Our Case Number: ACP-323972-25

Re: Public realm and community infrastructure project on lands in Ardee, Co. Louth
Ardee, Co. Louth

ACP-323972-25 – Louth County Council Public realm and community infrastructure project on lands in Ardee, Co. Louth

Character Area 2 : (Railway Memorial Park)

**HDC 1256 500 02**

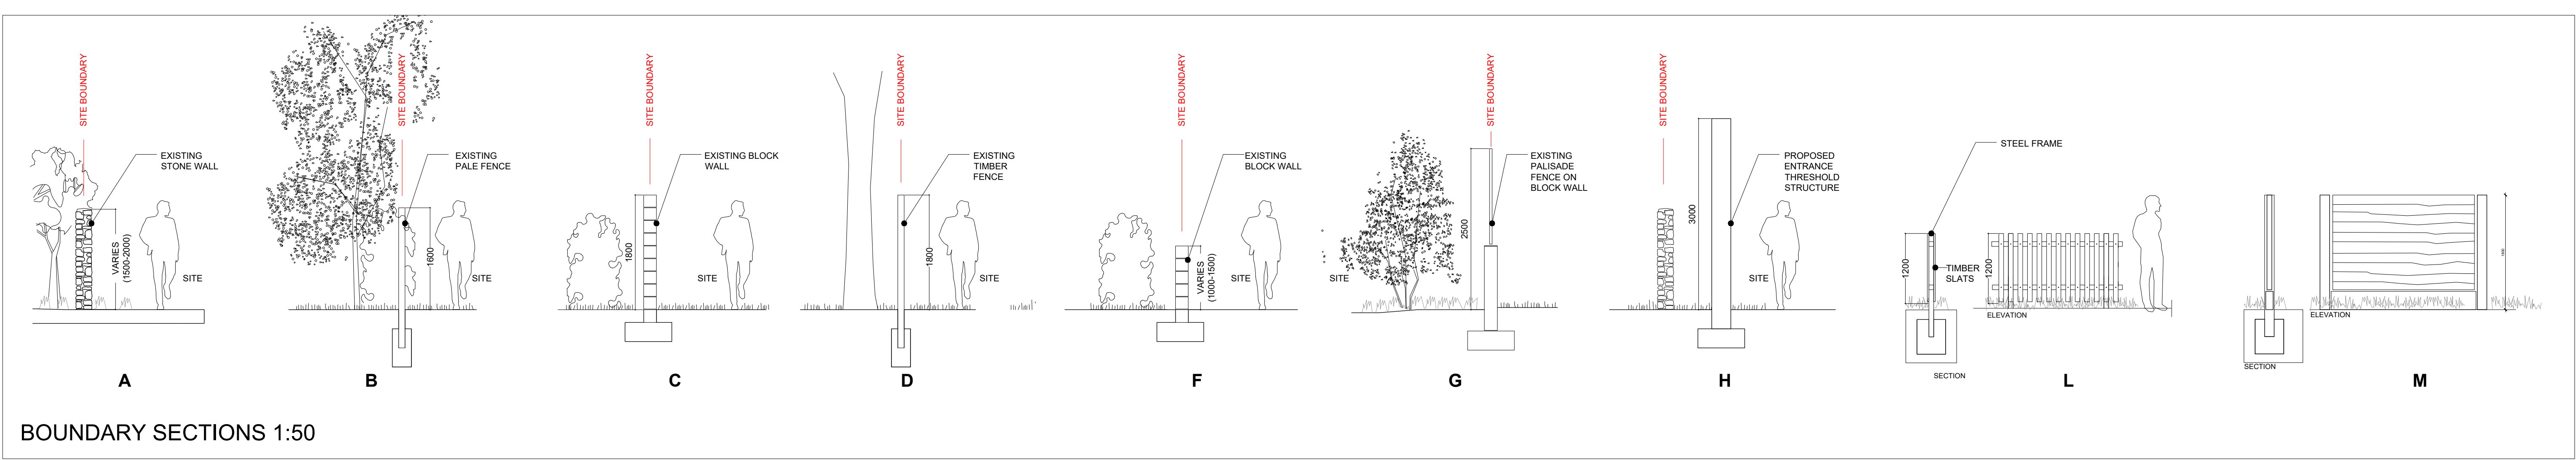
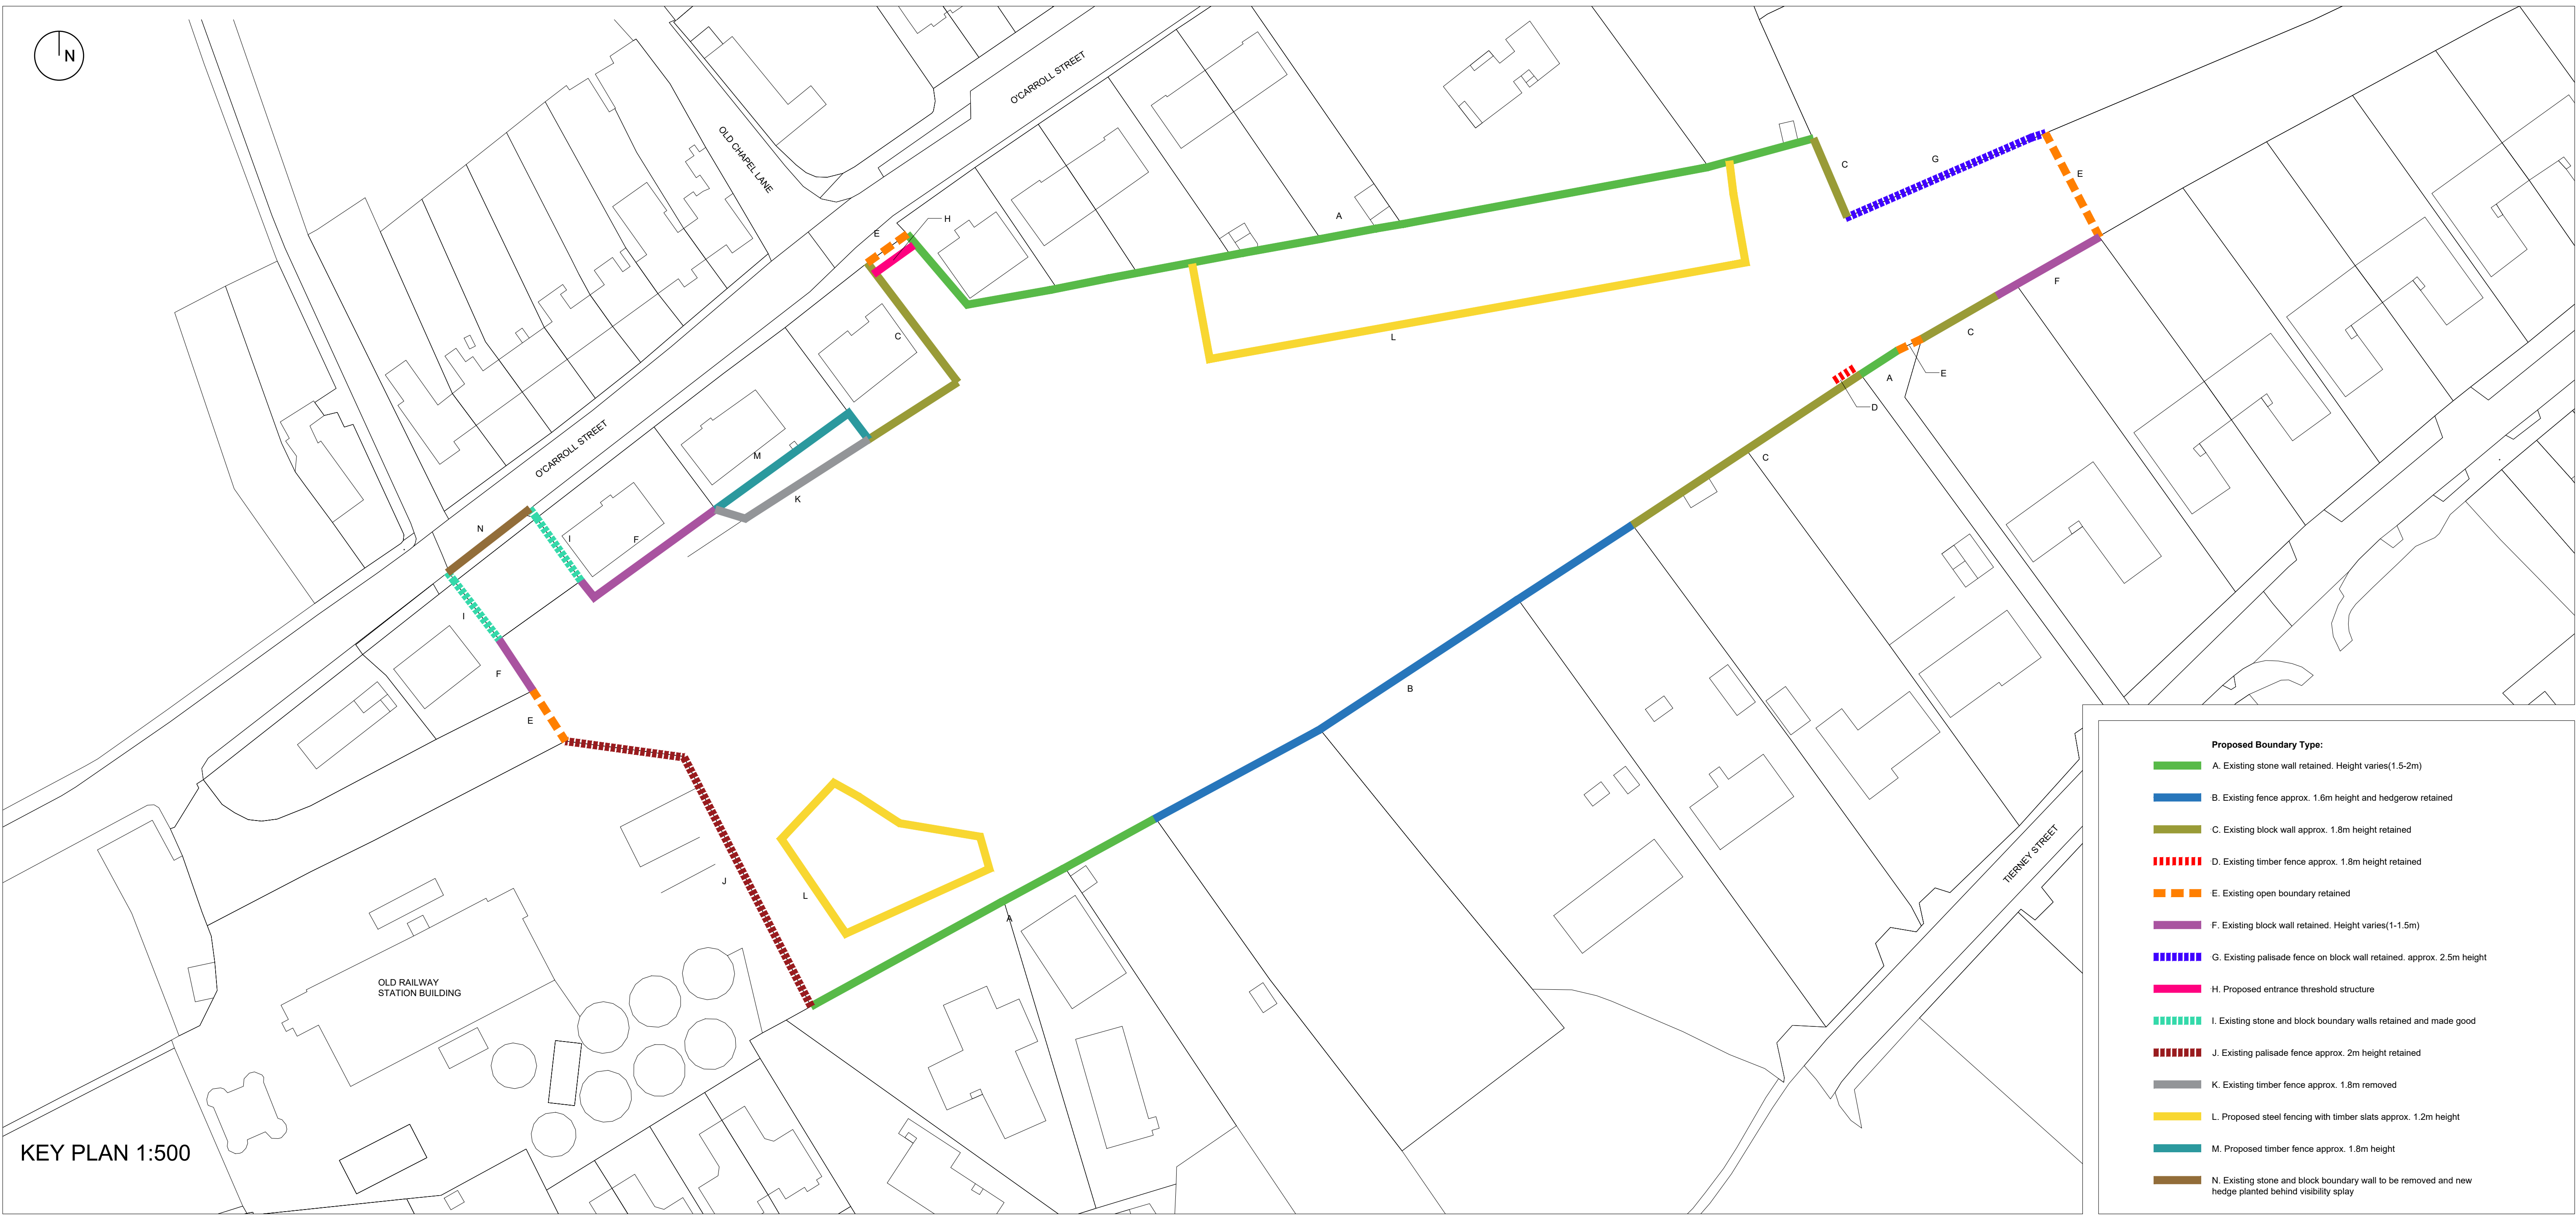
In essence, the drawings now relied upon in the planning application differ materially from those presented to the public during the September 2025 consultation process (see Appendix 2).

The earlier material depicted an open, permeable civic park landscape integrated with Memorial Park (Opportunity Area 2). The application drawings, by contrast, introduce extensive boundary enclosures, controlled access arrangements, vehicle access infrastructure, and a change in the functional use of key areas from reflective civic space to managed allotments.

- a playground;

- community allotments; and
- associated site uses.

The site maps and drawings accompanying the application do not show the existing well and grotto which are now in place within the Railway Memorial Park.

The well is an established commemorative feature and was formally opened by the then Chair of Louth County Council, Dolores Minogue. The omission of these features means the application does not accurately describe the existing condition or commemorative context of the site.

I formally request that the existing well and grotto be retained in situ as part of any future development of the Railway Memorial Park.
